**FINAL DRAINAGE REPORT
FOR
STERLING RANCH RECYCLING FACILITY**

May 2024

Project No. 25188.14

PCD Filing No: PPR2341 & SF2325

PROPOSED DRAINAGE MAP

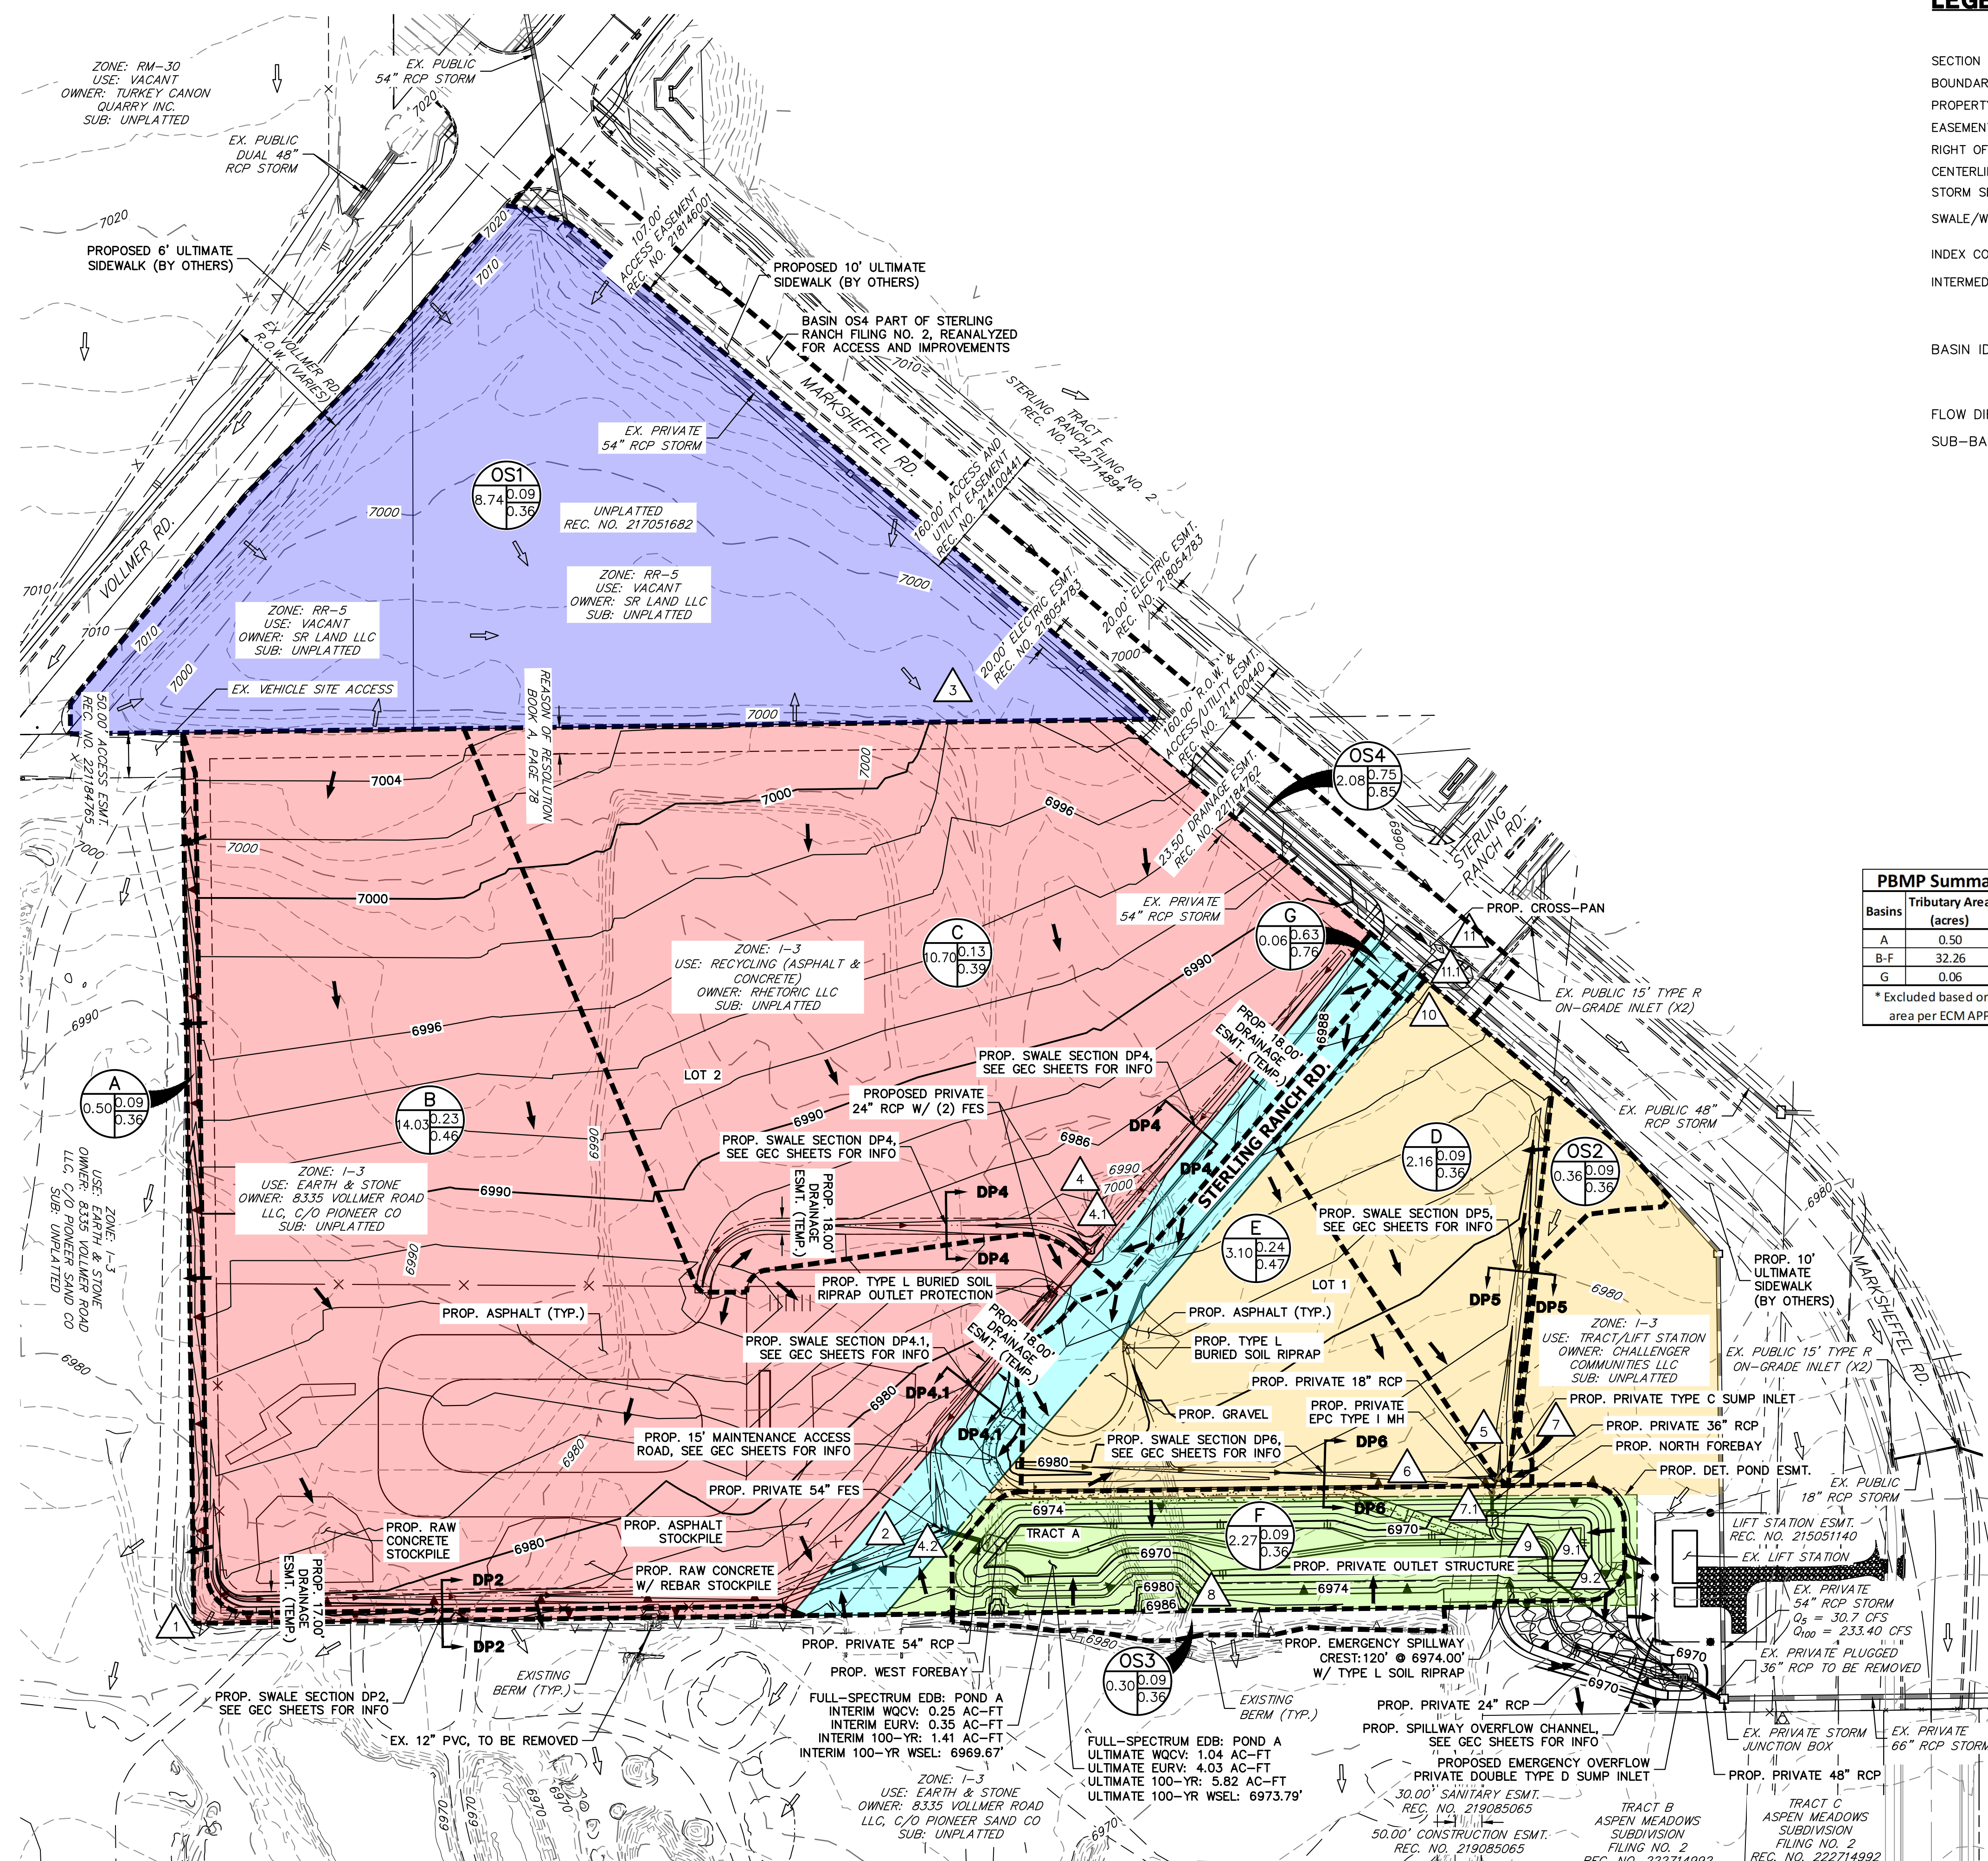
Clarify that this means that WQ treatment is accounted for for this basin that is within the LOD for this project. Providing a EDARP File # and/or an excerpt from that previous report would be helpful too.
